Application No: AB/76/21/L
Site Address: 54 Tarrant Street Arundel BN18 9DN
Description of works: Listed building application for alterations to fenestration and installation of 4 x new rooflights and waterproofing system to basement and outbuilding.

Thank you for your internet representation made on 28th June 2021 which has been recorded as an objection with the comments as follows:

OWPC37770

PROPOSED DETAIL FOR
WINDOWS W6, W7, W8 + W9
WHICH WILL BE DOUBLE GLAZED

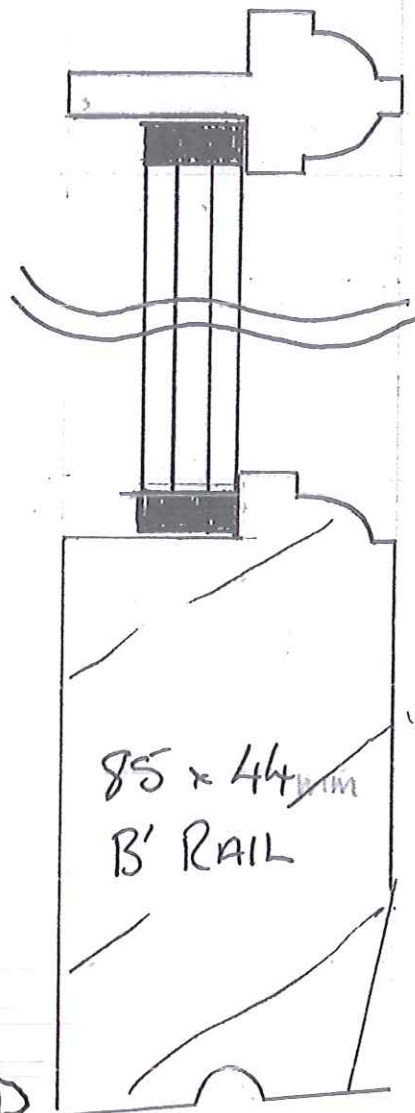
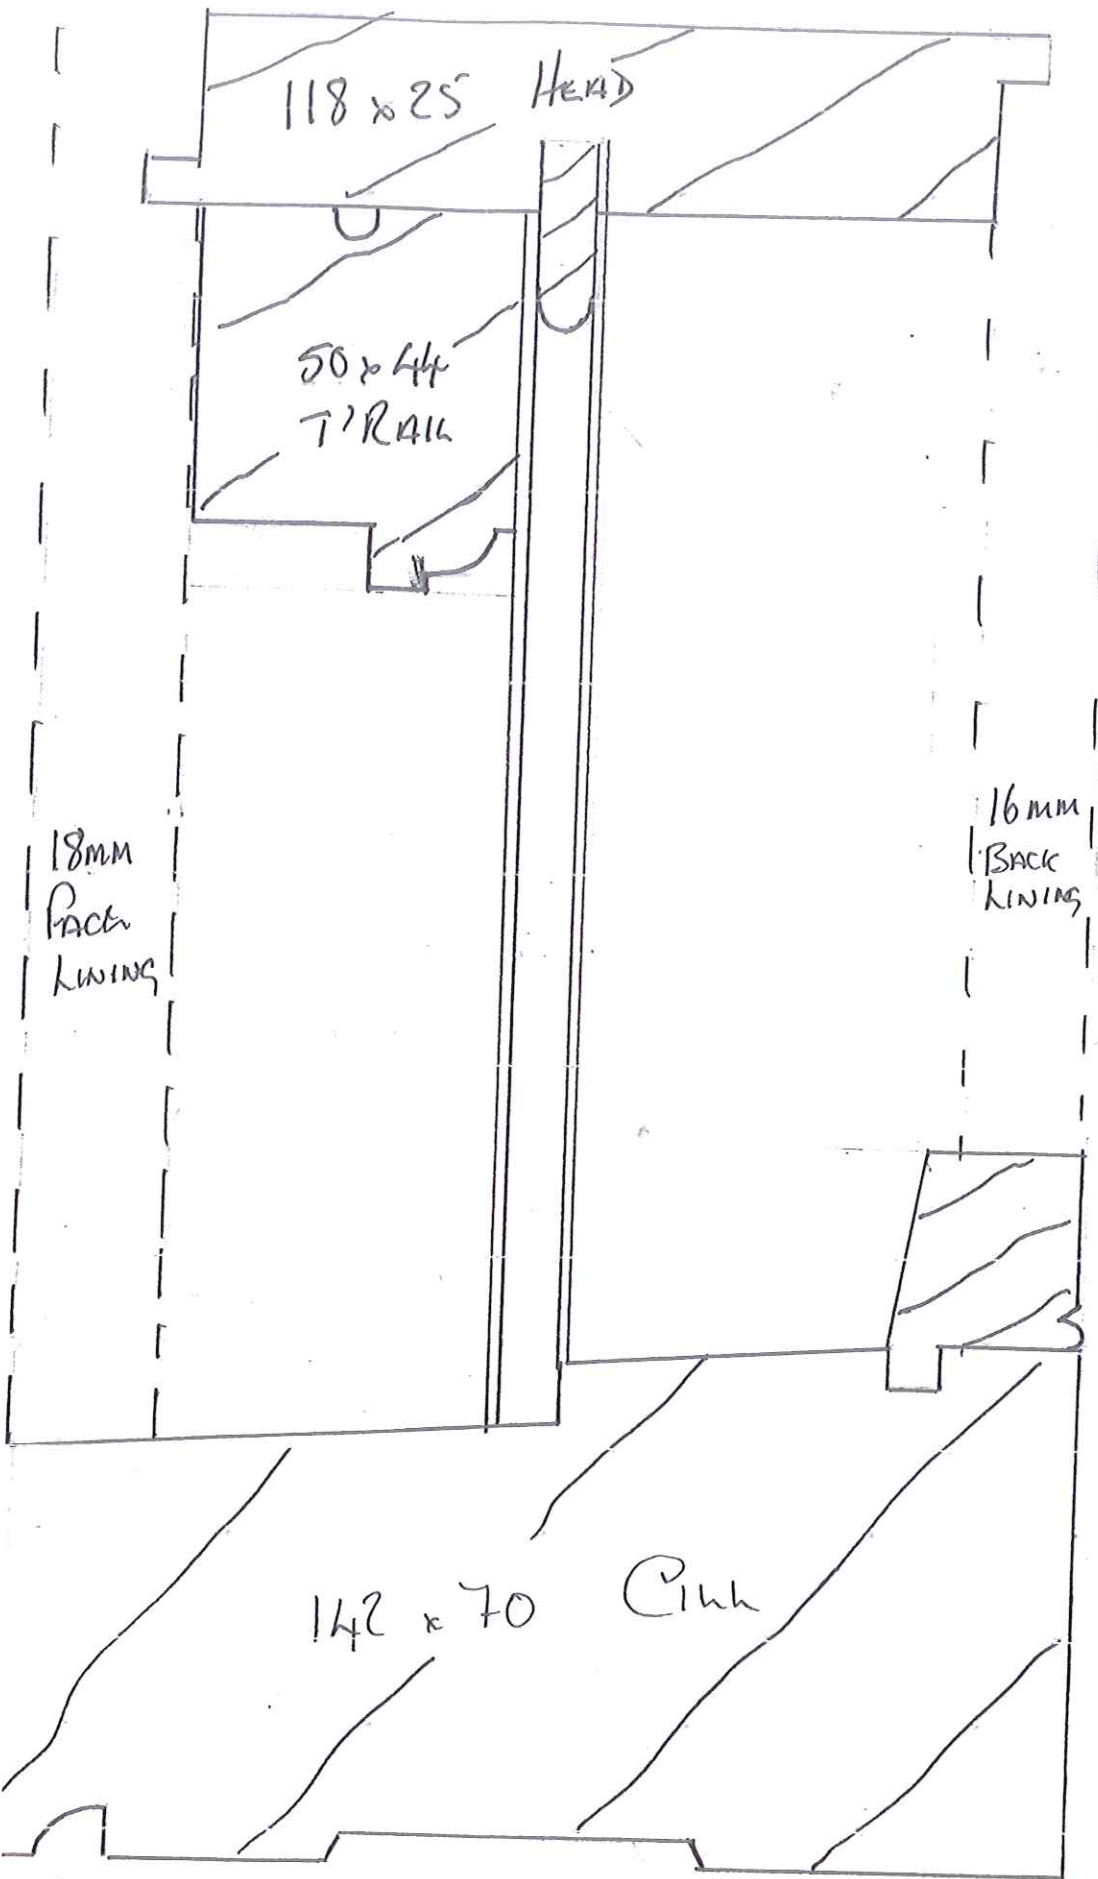
The Committee objected to the Application on the grounds that the double glazed windows cause harm to the character and significance of the Grade II Listed Building and the designated Conservation Area in conflict with HER DM1 and HER DM3 of the Arun Local Plan and the National Planning Policy Framework.
